From: Pat Aird
Sent: 15 June 2018 12:59
To: 'Graham Moore'
Subject: RE: Planning Consultation on: AB/16/18/L

Longmace House, High Street , Arundel.

APPLICATION AB/16/18/L

Description of Works: Listed building consent for the part change of use from business (A2 Financial & Professional Services) to residential use (C3 Dwellinghouse) on part ground, 1st & 2nd floors.

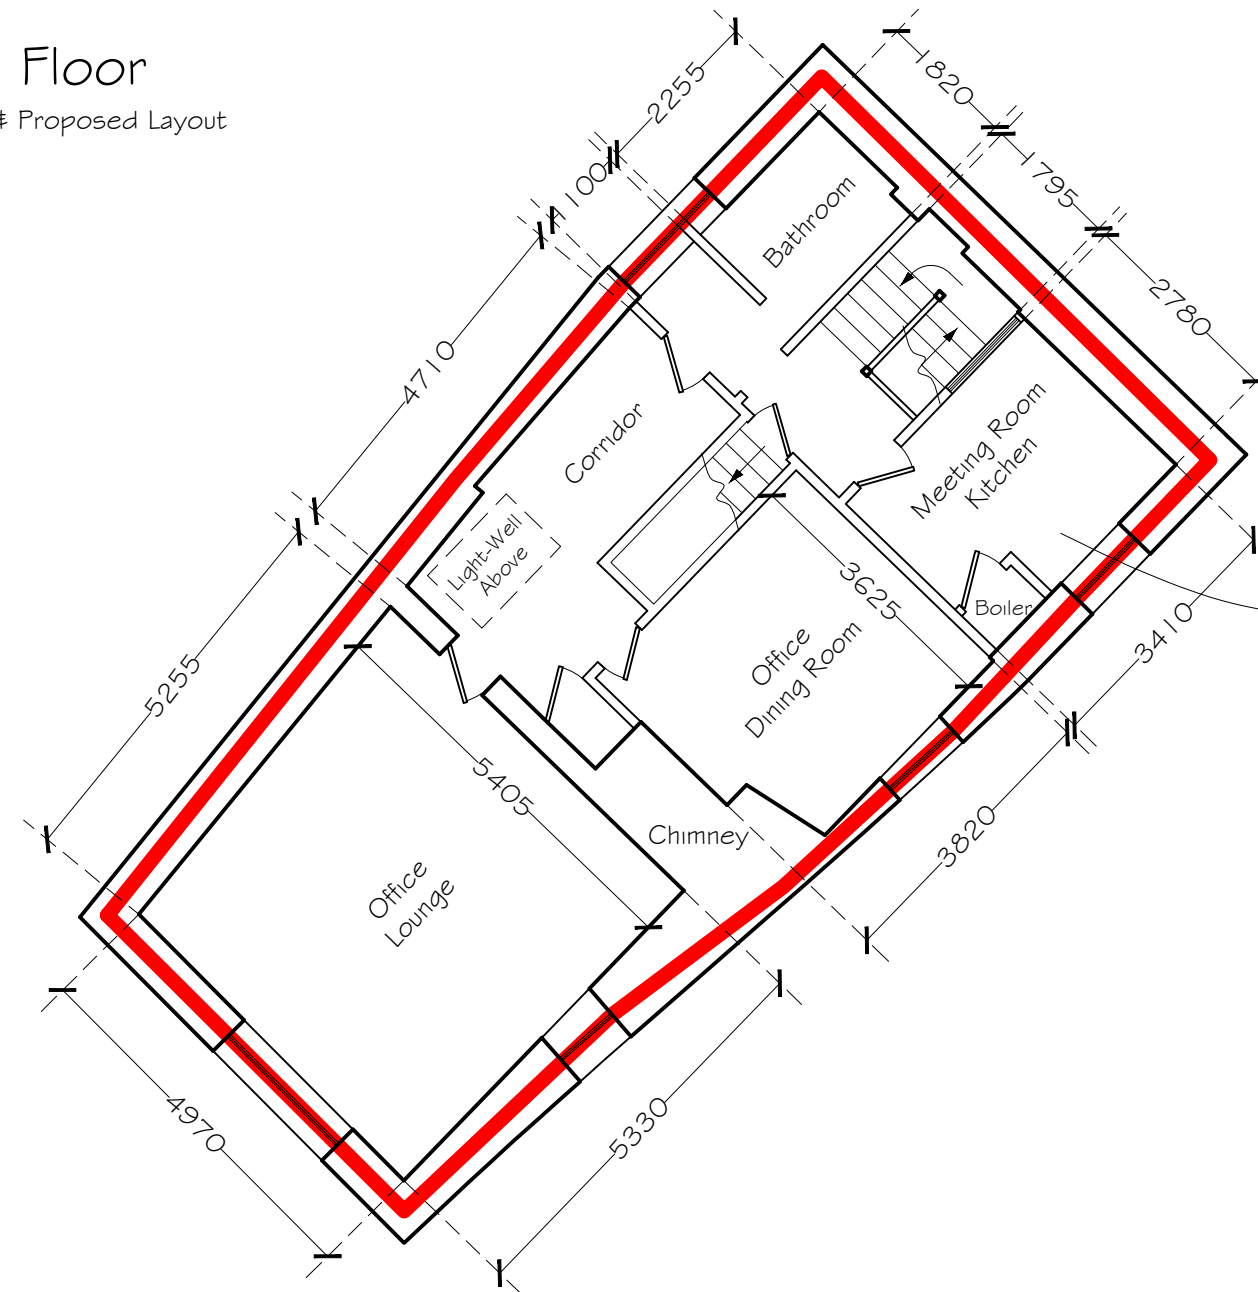
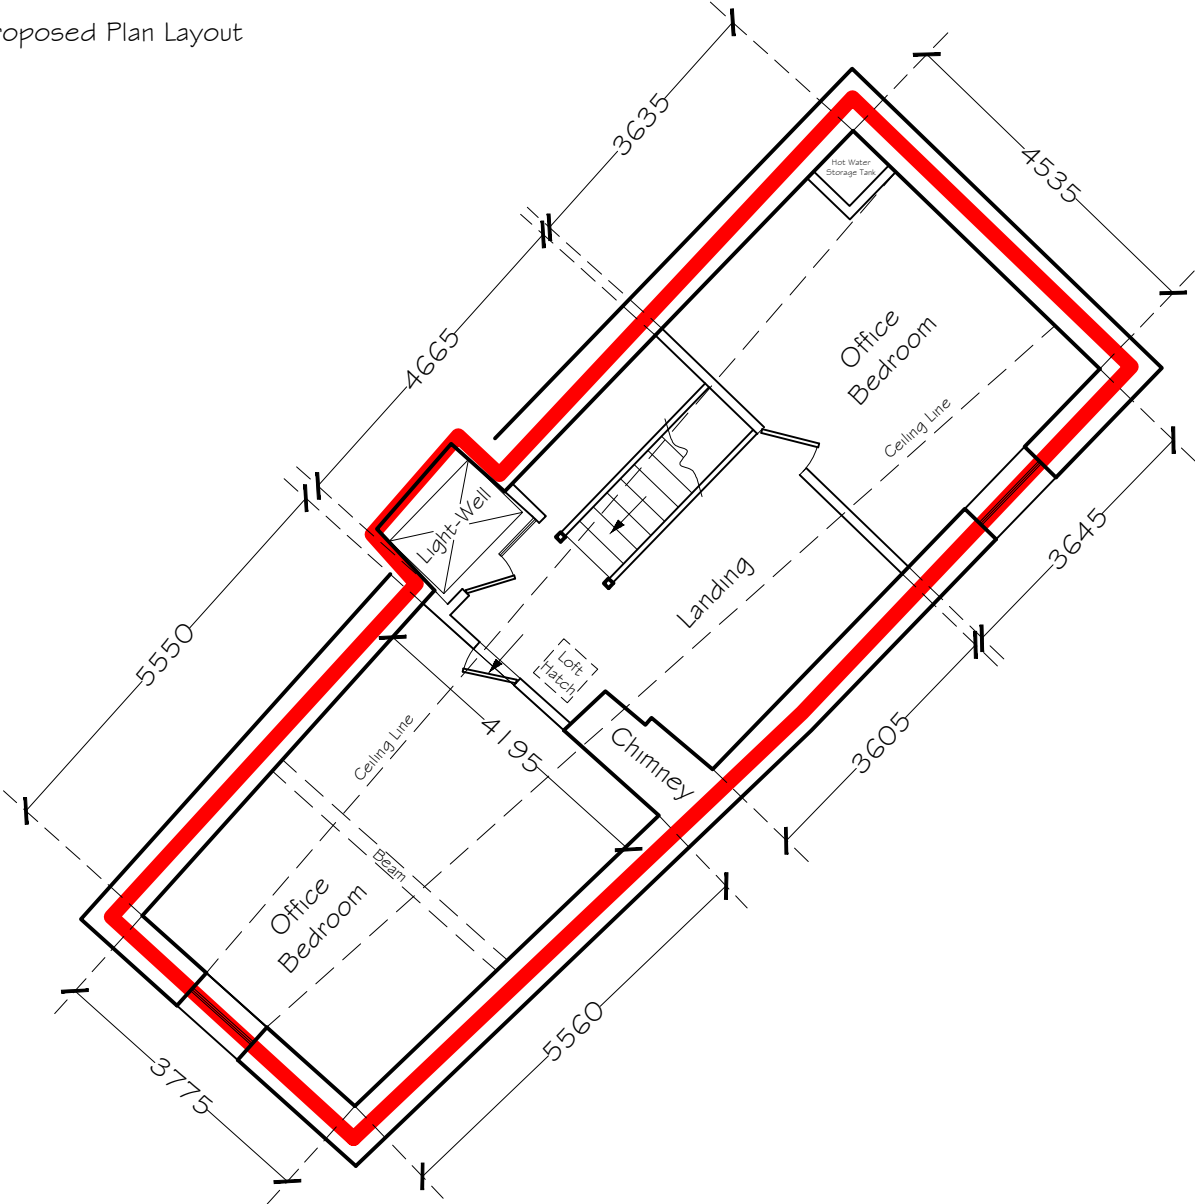
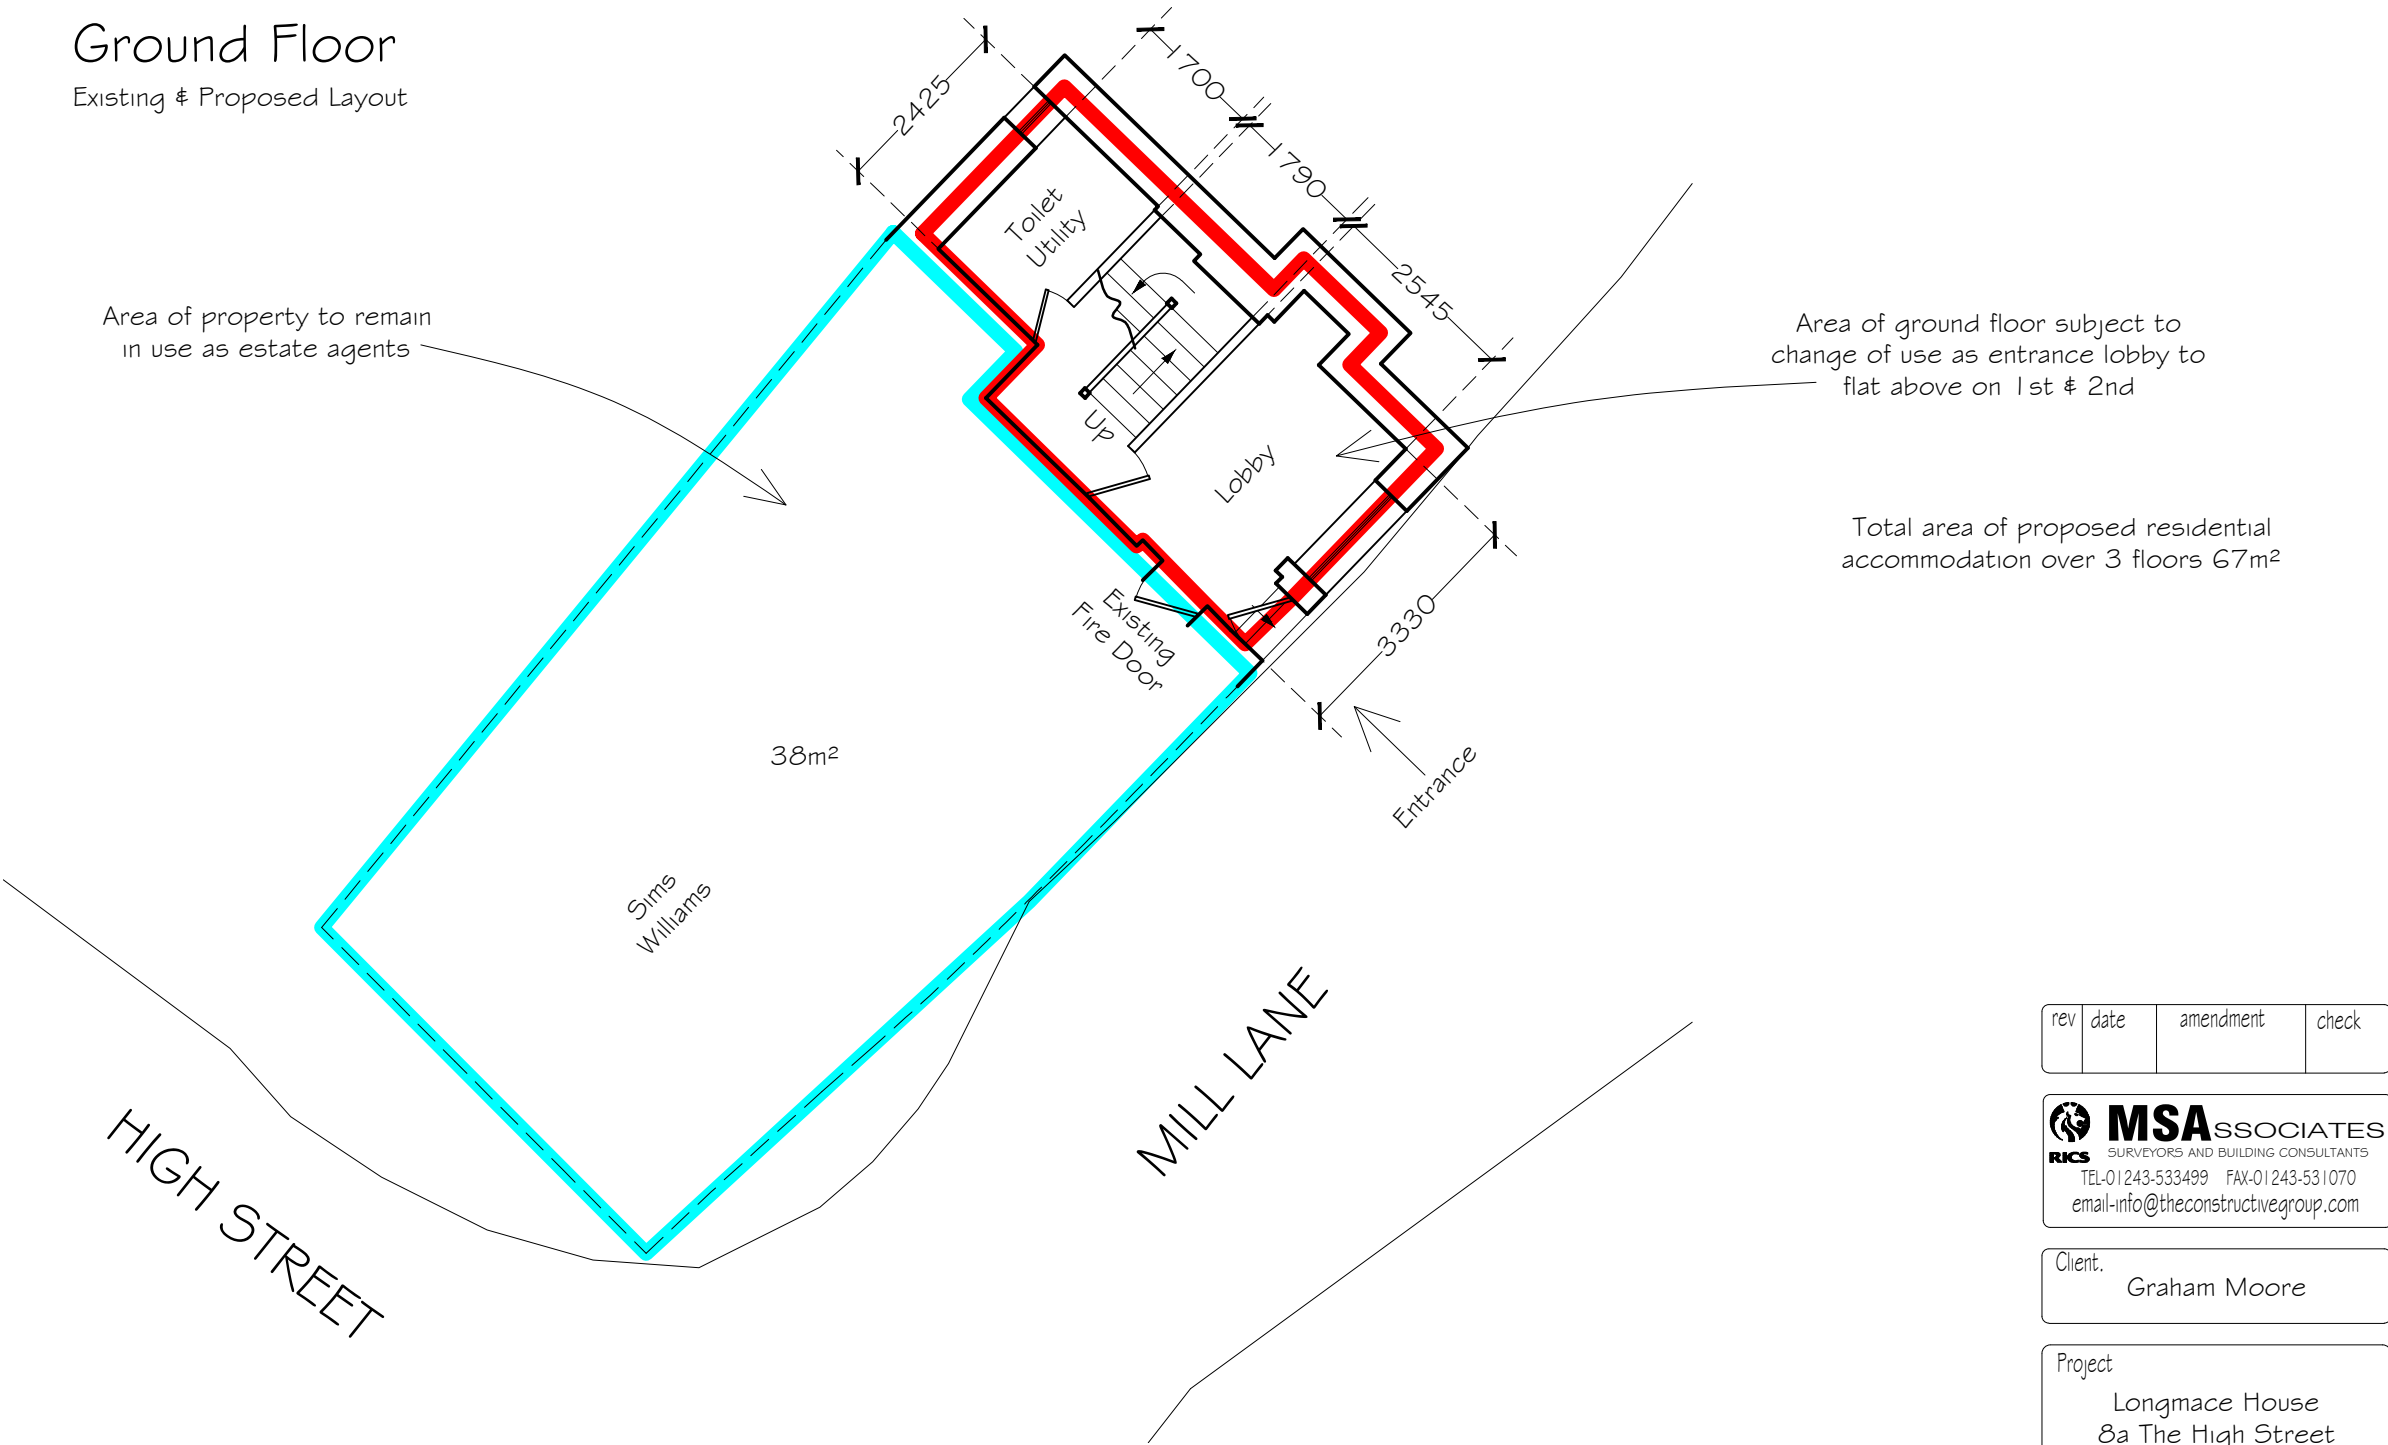
We require you to clarify how the change of use will be achieved and detail any internal alterations required. If there are no alterations, then this needs to be explained. We need to be clear as to exactly what the change of use will involve and the method which would be used to achieve this.

I have been invited to make comment on the below application. While there are no general concerns on the Change of Use from a Conservation point of view, there are no details given on how this the applicant wishes to achieve this. The submitted drawings are marked 'Existing & Proposed', with general comments eg 'bathroom', without any methodology. It is therefore my professional opinion that there are insufficient details to properly comment on this application. I would be pleased to meet the applicant to discuss.

The layout remains as it was when it was residential so there are no internal alterations proposed.

In fact, the bathroom retains a bath and has not been altered at all.

I suspect that we should replace the sanitaryware and kitchen units but all services remain for direct replacement.
